From: Carol Reynolds
Sent: 06 February 2017 14:00
To: Planning.Responses
Subject: FW: Planning Consultation on LU/356/16/DOC

APPLICATION LU/356/16/DOC
NO:

Registered: 23-DEC-16
Site Address: Land north of 31-40 Joyce Close Littlehampton BN17 7JG
Description of Works: Application for approval of matters reserved by condition imposed under LU/221/14/PL relating to condition no. 3 (Schedule of materials & samples), 4 (new screen walls /fences), 5 (surface water drainage), 6 (landscaping scheme), 10 (cycle parking spaces) & 11 (scheme for protecting the proposed dwellings from noise from road traffic noise)

PROPOSED Acoustic Fencing

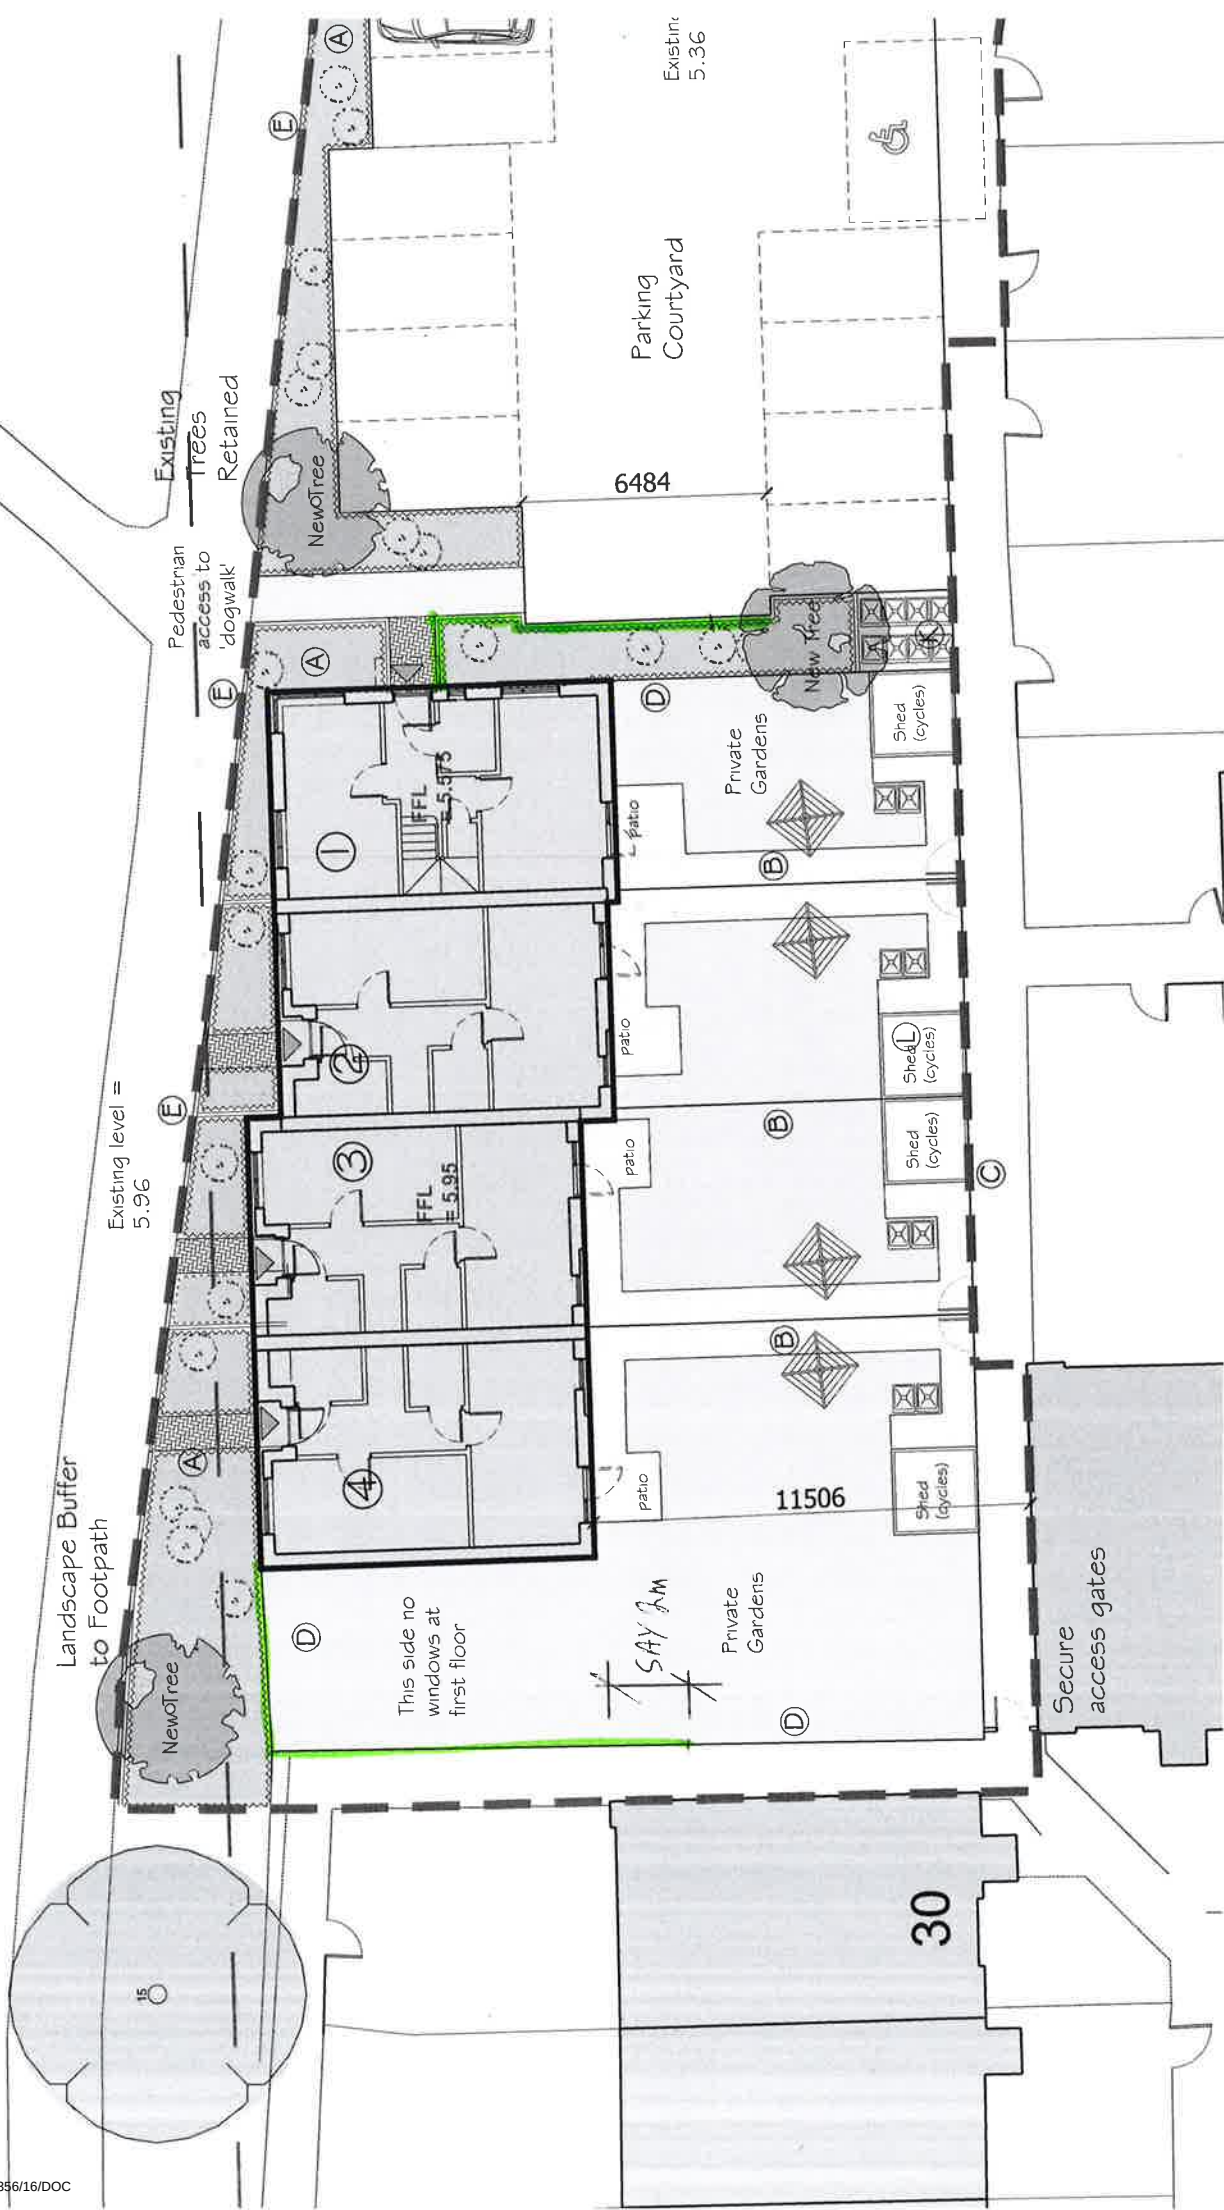
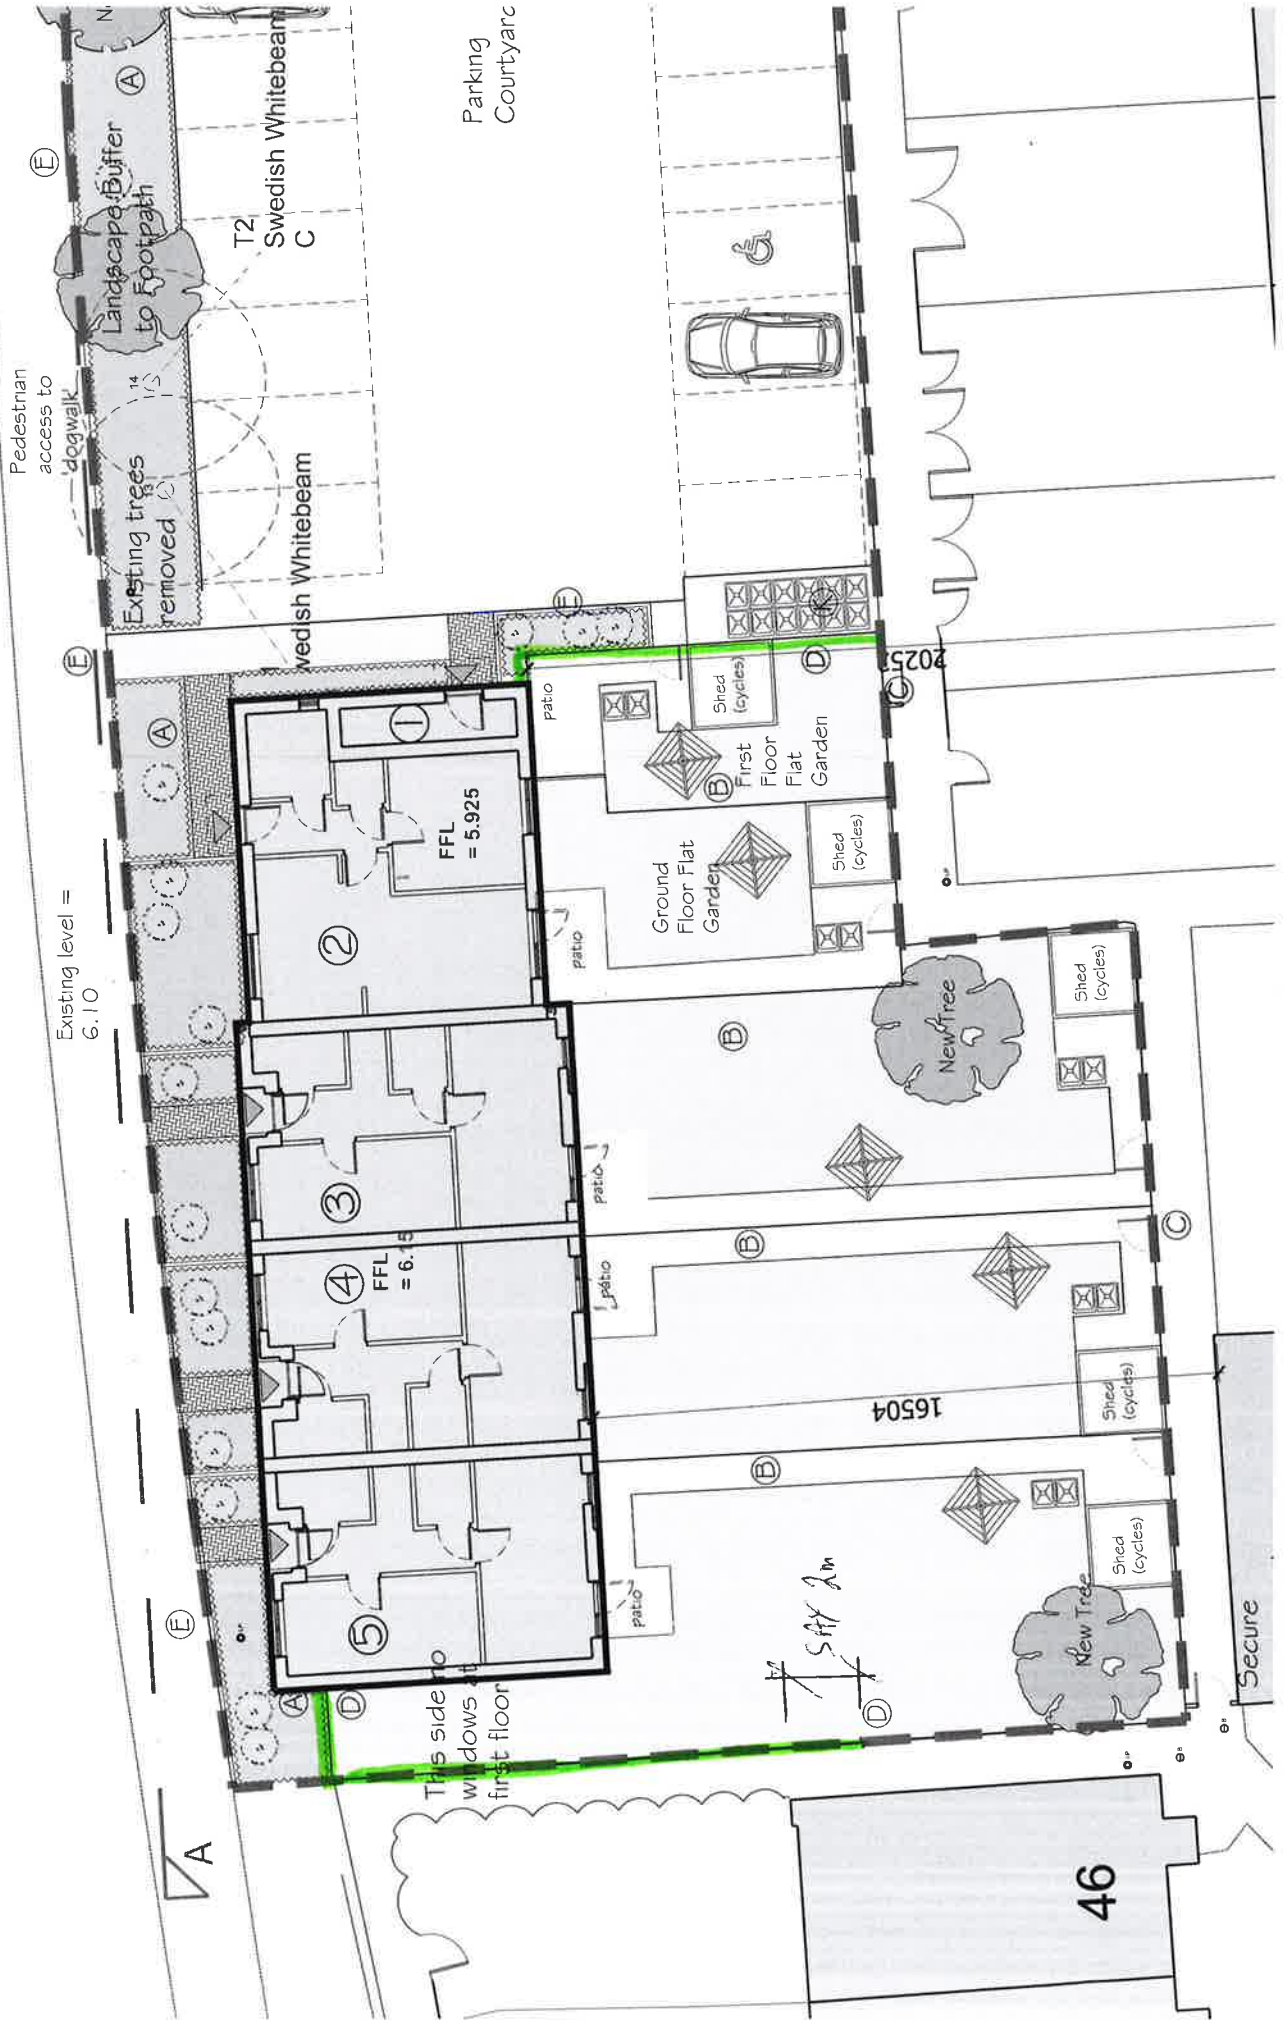
Condition 4: Acoustic Screening to External Amenity Space.

The World Health Organisation identifies that a sound pressure level in gardens, etc., of greater than 55dBAeq is likely to give rise to serious annoyance. The Environmental Noise Assessment prepared by Ian Sharland Ltd, Noise & Vibration Specialists 29 April 2014 in respect of infill of residential units in the combined Greenfields and Joyce Close (para 5.11 -14) indicates that daytime noise levels to the majority of garden areas lie within with in the unsatisfactory 55-60dB(A) noise level. The Acoustic Barrier provision as detailed in the applicant's report does not accord with the specification requested in the above Environmental Noise Assessment. Please provide suitable proof that this alternative will provide at least the same attenuation as the design brief. Until this information is received then I unfortunately cannot agree to discharge of this Condition.

Project & Drawing title					
PROPOSED PLANS AND ELEVATIONS					
Drawn	Date	Checked	Date	Scale at A1	
CK	19/02/14	NKS	19/02/14	1:100	
Job N°	13-076	Drawing N°	PL 02	Rev.	A
Status	PLANNING

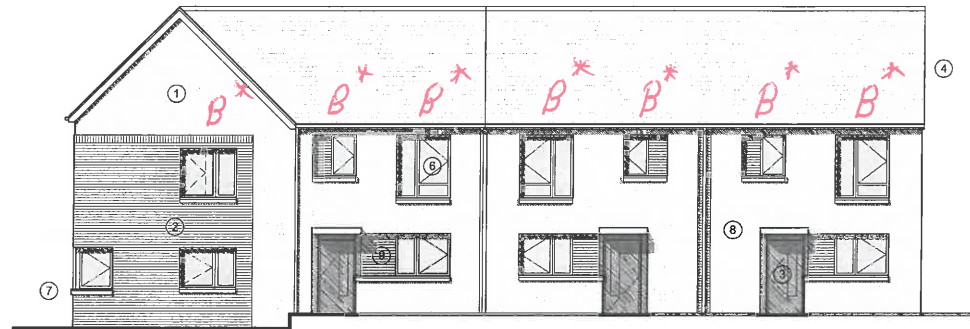
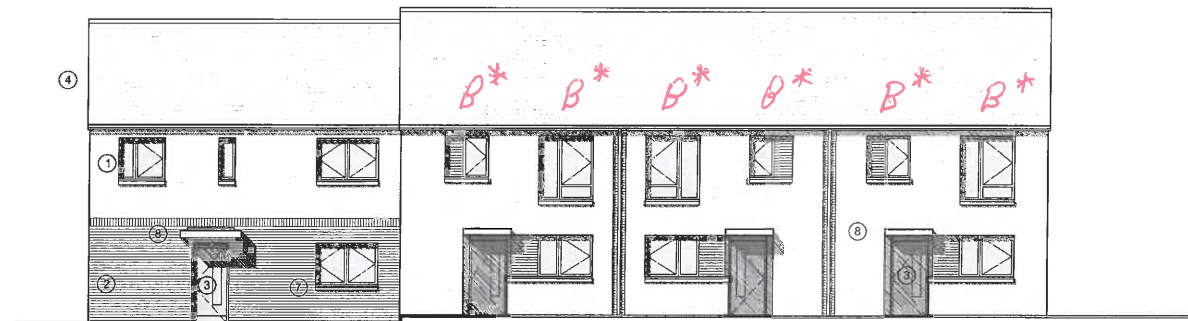
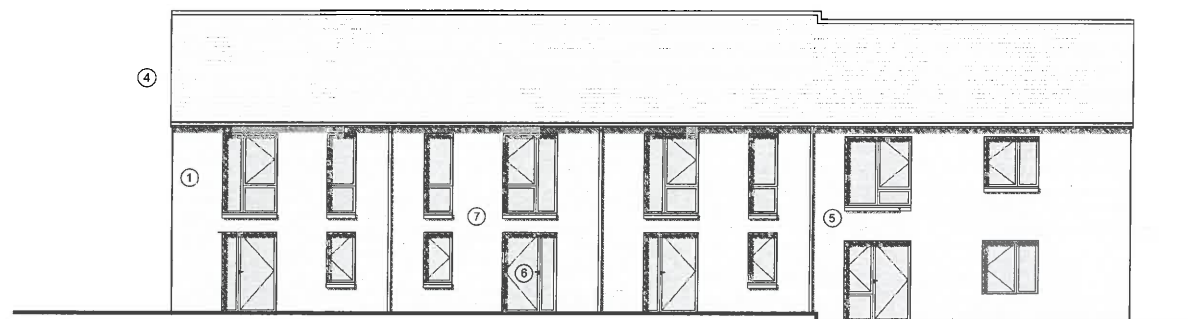
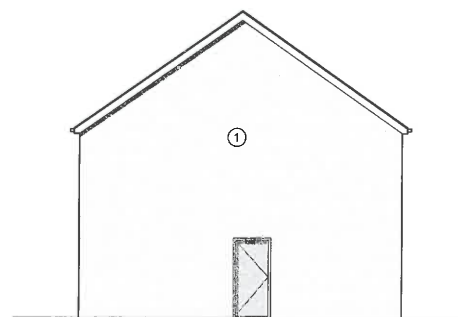
Condition 11 : Noise Protection to Internal Amenity

The Environmental Noise Assessment prepared by Ian Sharland Ltd, Noise & Vibration Specialists 29 April 2014 in respect of infill of residential units in the combined Greenfields and Joyce Close, advises (para 5.7) that alternative means of ventilation may be necessary where opening a window to a habitable room would result in excess noise to that area. Further (para 5.8) that such an alternative method should be determined by the Architect, in liaison with the Local Authority which should be passed back to the Acoustic Consultant for confirmation of whether this would provide an appropriate means of attenuation (para 5.9). Please note that this Department does not accept passive acoustic trickle vents. Acoustically treated mechanical means of ventilation will be required. Since I am unaware of any such liaison then I am unable to agree to discharge of this Condition.
